**Harbourside Shopping Centre Redevelopment SSD-7874
Amended Concept Proposal and Stage 1 Early Works October 2020 and
Response to submissions**

My submission is to OBJECT based on the grounds that the minor changing to the northern podium do not :

Image 83 Images Above - View from 50 Murray St residences

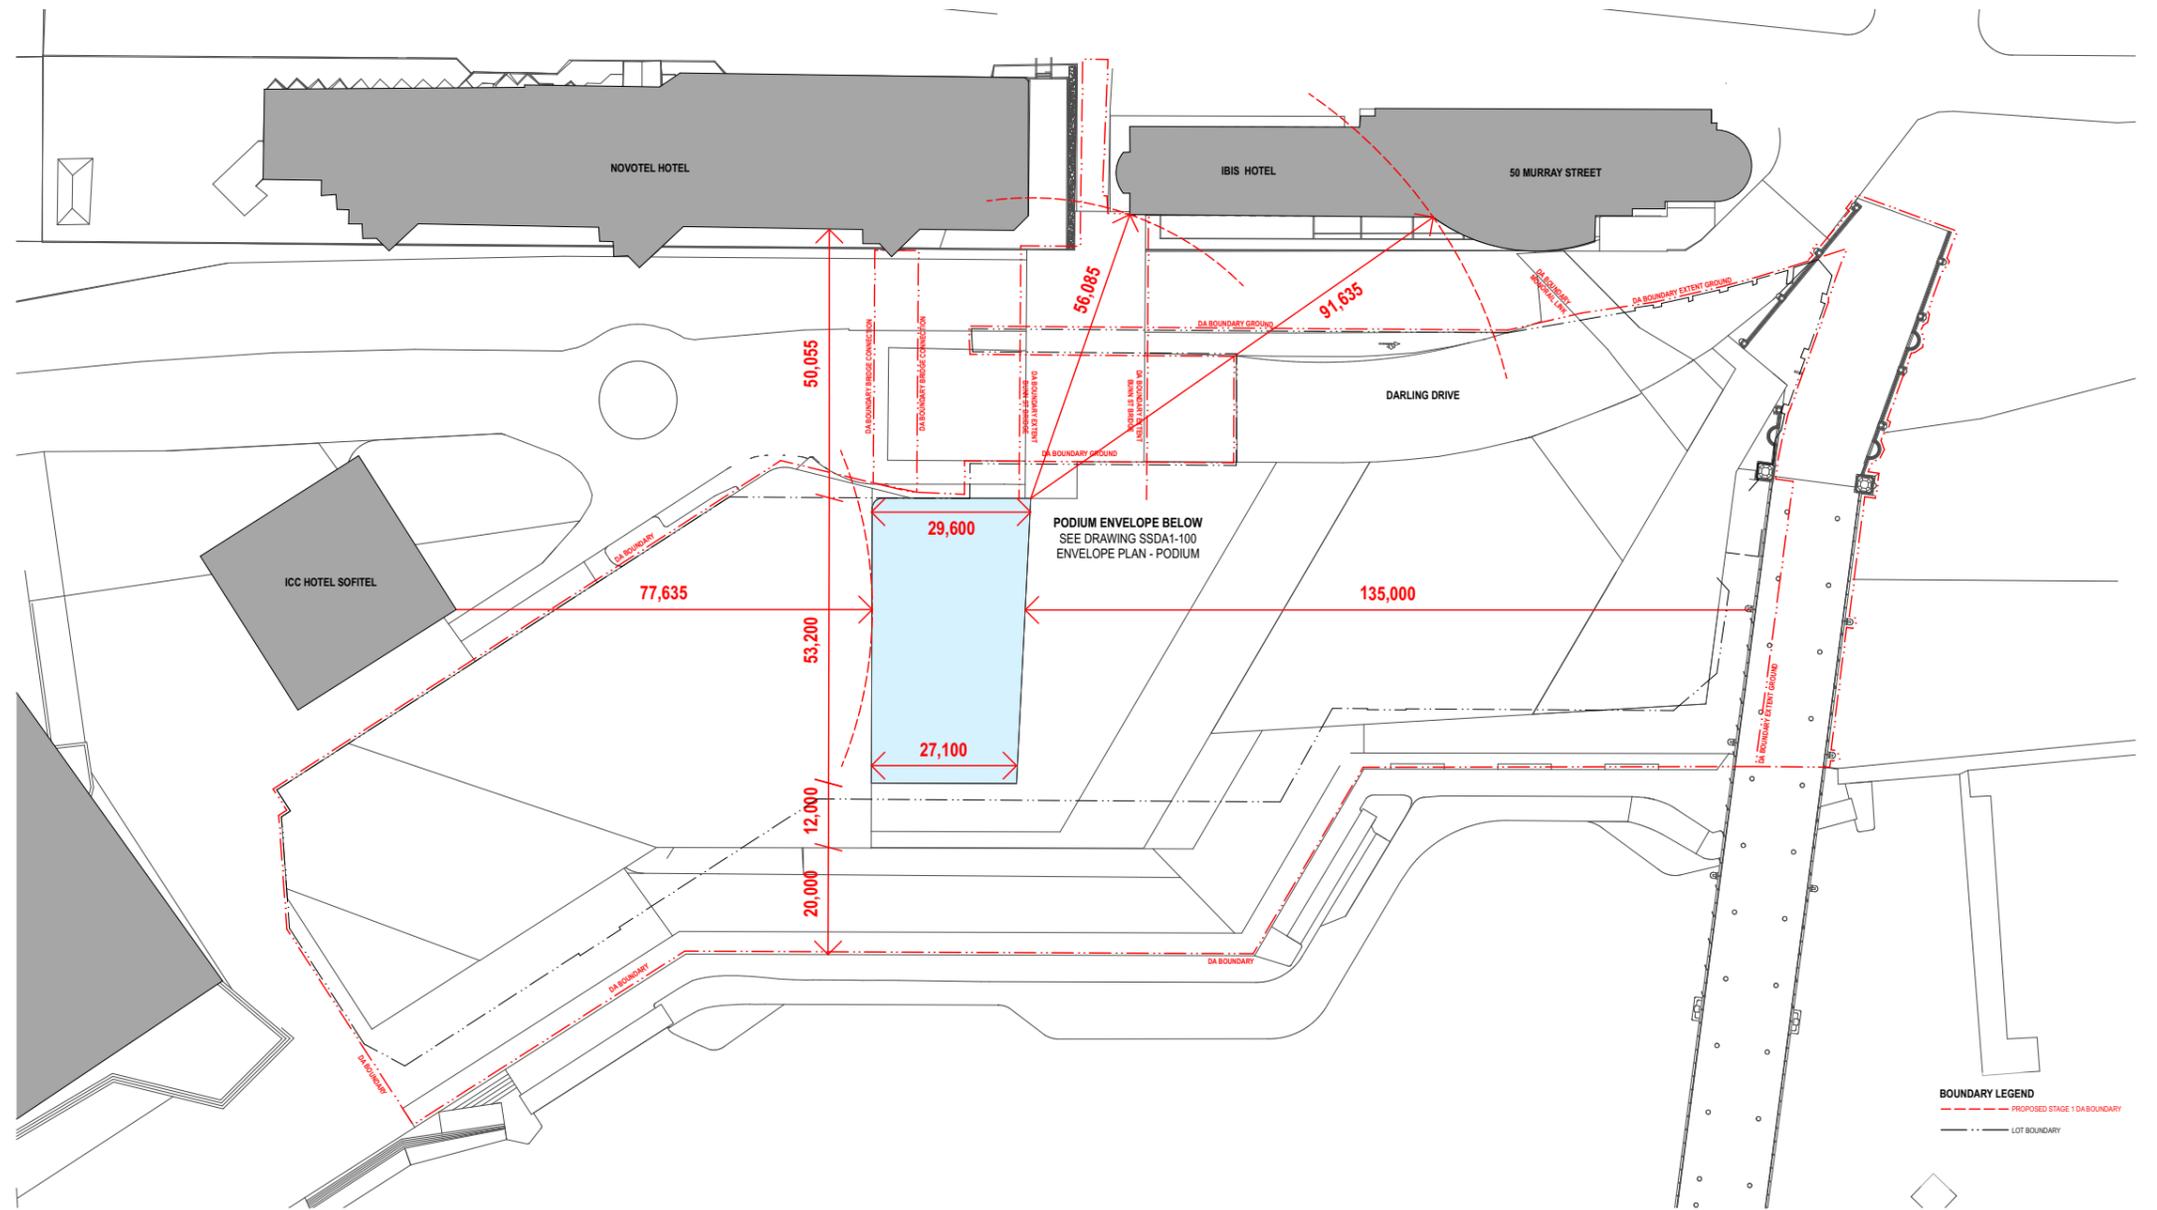
The majority of the **east facing** apartments of 50 Murray Street have highly valued views that enjoy **whole water views of Cockle Bay**. Every aspect (Floor to ceiling glass) of the apartments, in addition to the balcony, have a view of the water. With the previous concept, all east facing apartments at level 8 and below totally lost all Cockle Bay views. The amended concept as shown below still has east facing apartments losing all Cockle Bay water views.

The proponent claims that by introducing a north east facing 'channel' it provides views north of Pyrmont Bridge and thus claims it has '*significant improved view sharing of 50 Murray Street*'. This is an **unacceptable claim**. It has been pointed out that east faced of 50 Murray Street is a curved. Providing a north east channel at the north end of the proposal has no impact on sharing the water views of Cockle Bay.

Views from curved 50 Murray Street are inconsistent with the provision of a channel view platform to the north east claiming to have 'significantly improved view sharing of 50 Murray Street'

Image 88 Envelope Diagram - East Elevation

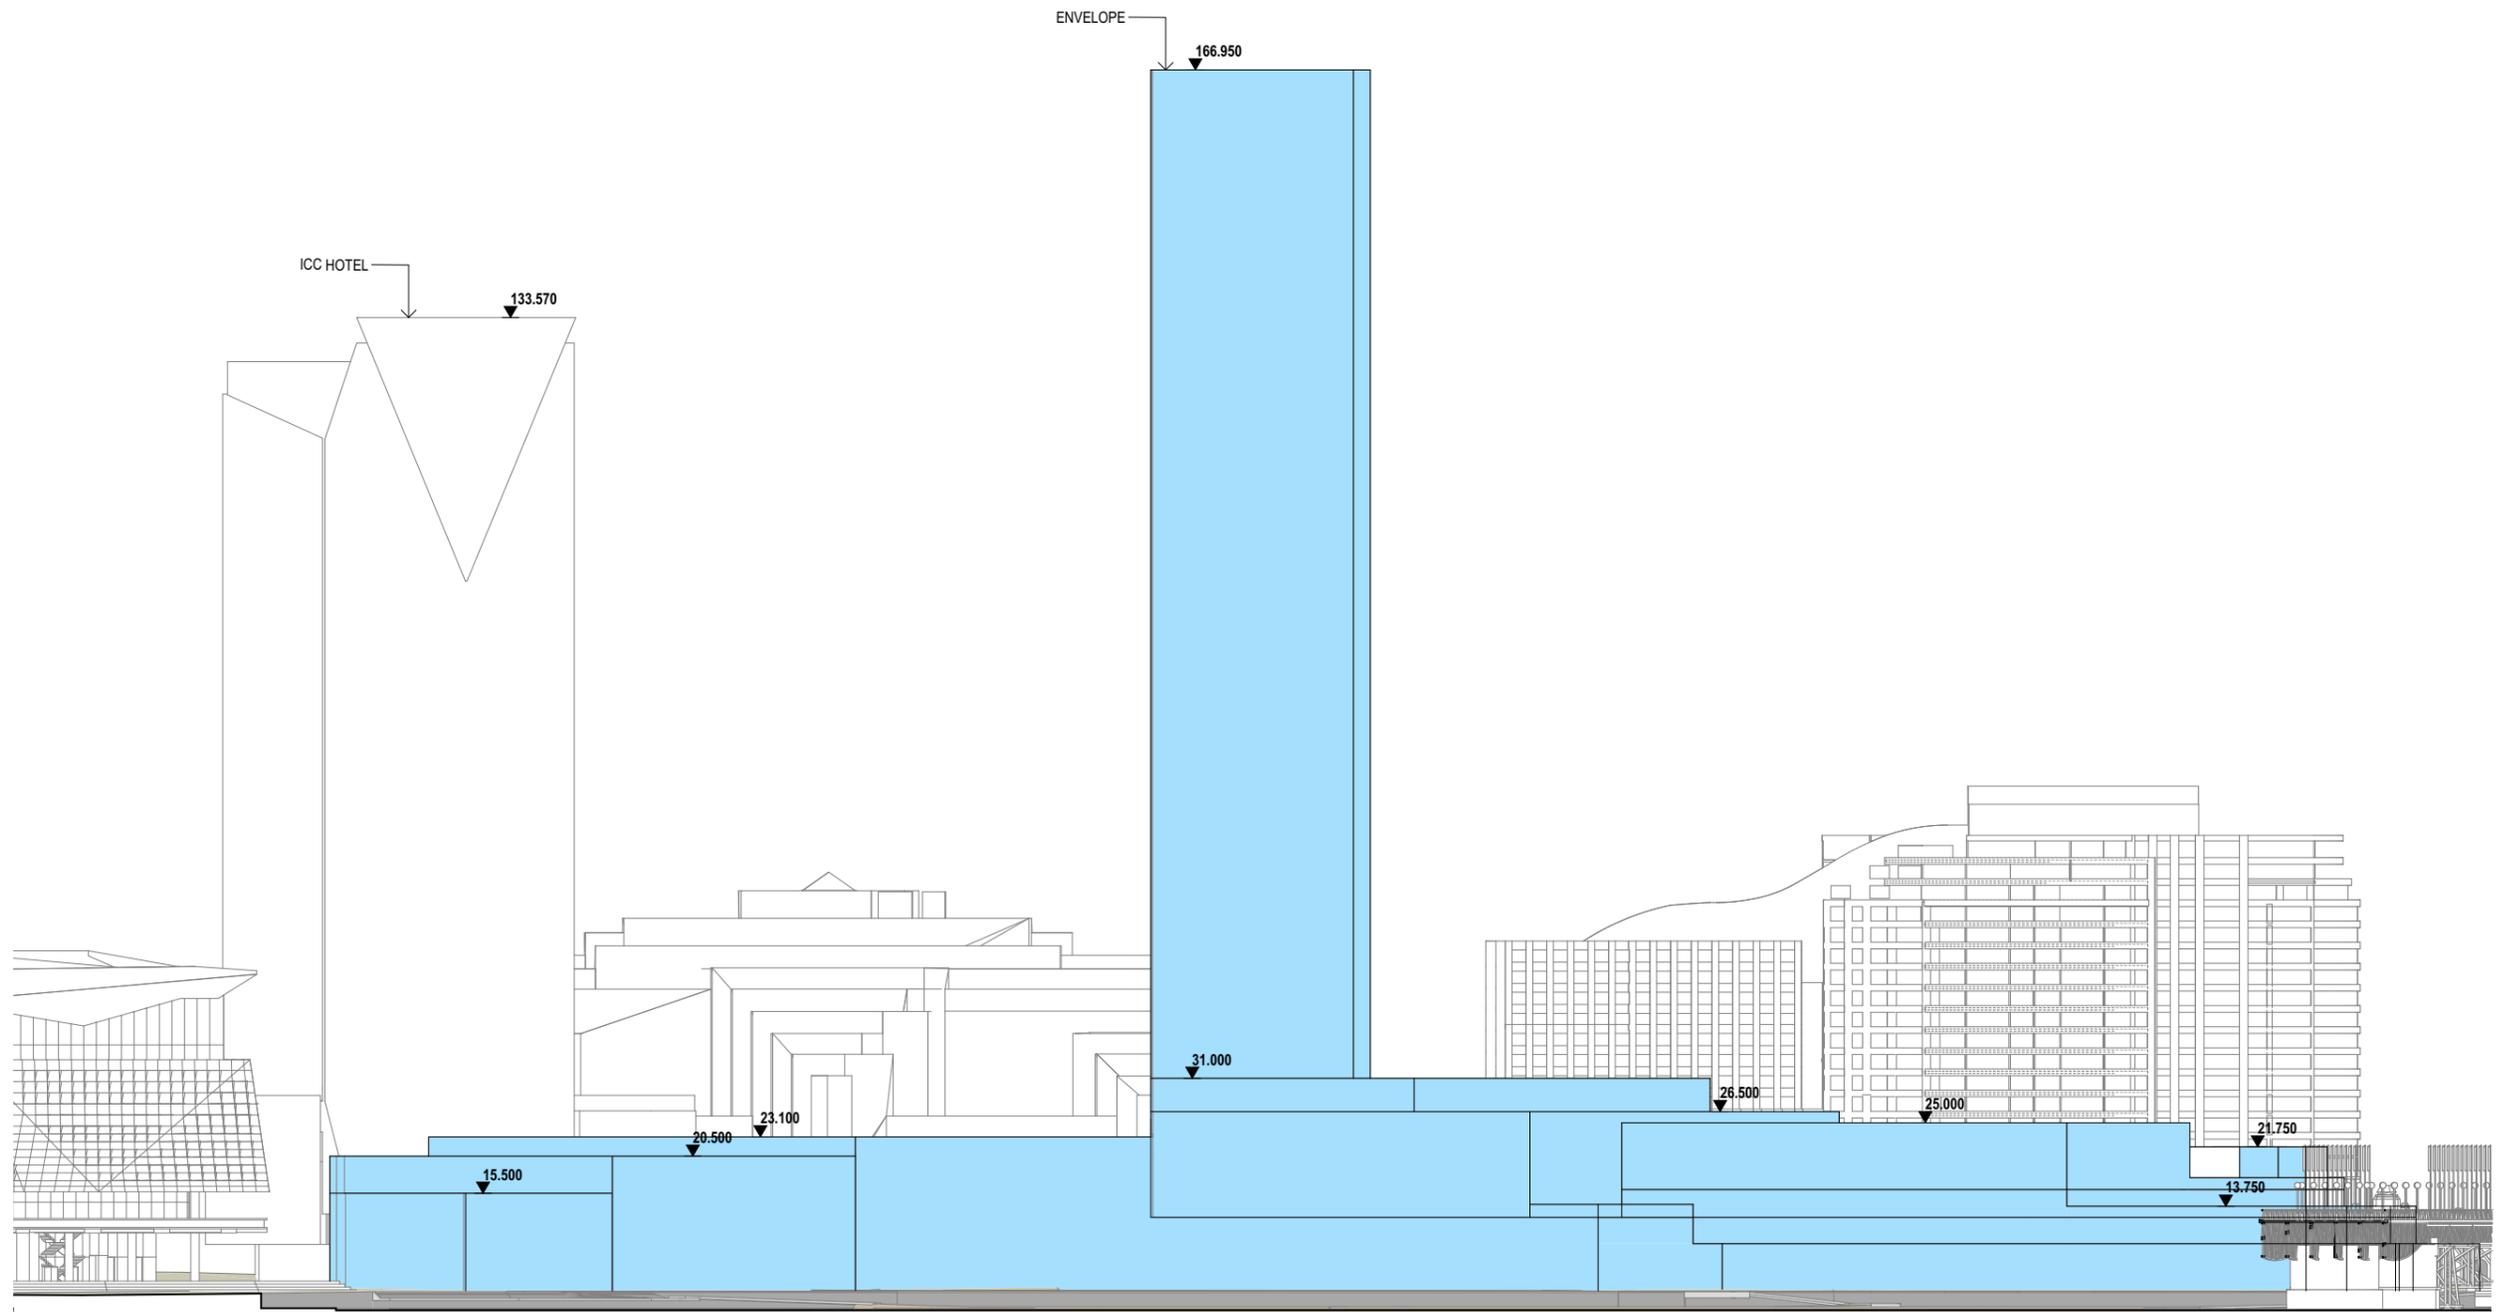
The podium setback to Pyrmont Bridge is only some 25 meters where the RL rises from 13.75 to RL 25 which still significantly overpowers the State listed Pyrmont Bridge. The Cockle Bay side of the Pyrmont Bridge has an RL of 12 for 65 meters.

In contrast, the Harbourside Shopping Centre Redevelopment proposal is for a two level park RL's of 13.75 and RL 17.6 extending away from the Pymont Bridge by only some 30m before rising to 25, proposing and RL of for the northern portion of the podium rising to RL 26.5 and then RL31.

- Sharing of views of Cockle Bay particularly from 50 Murray street; and
- the character of the precinct and the consistency of the experience and vibrancy of Cockle Bay as well as its various landmarks particularly heritage elements such as the Pyrmont Bridge it is recommended to amend the proposed envelop for the northern portion of the podium to maintain the RL 13.75, but extend the RL 17.60 such that it extends 85m from Pyrmont Bridge. Such an outcome would negate or objection.
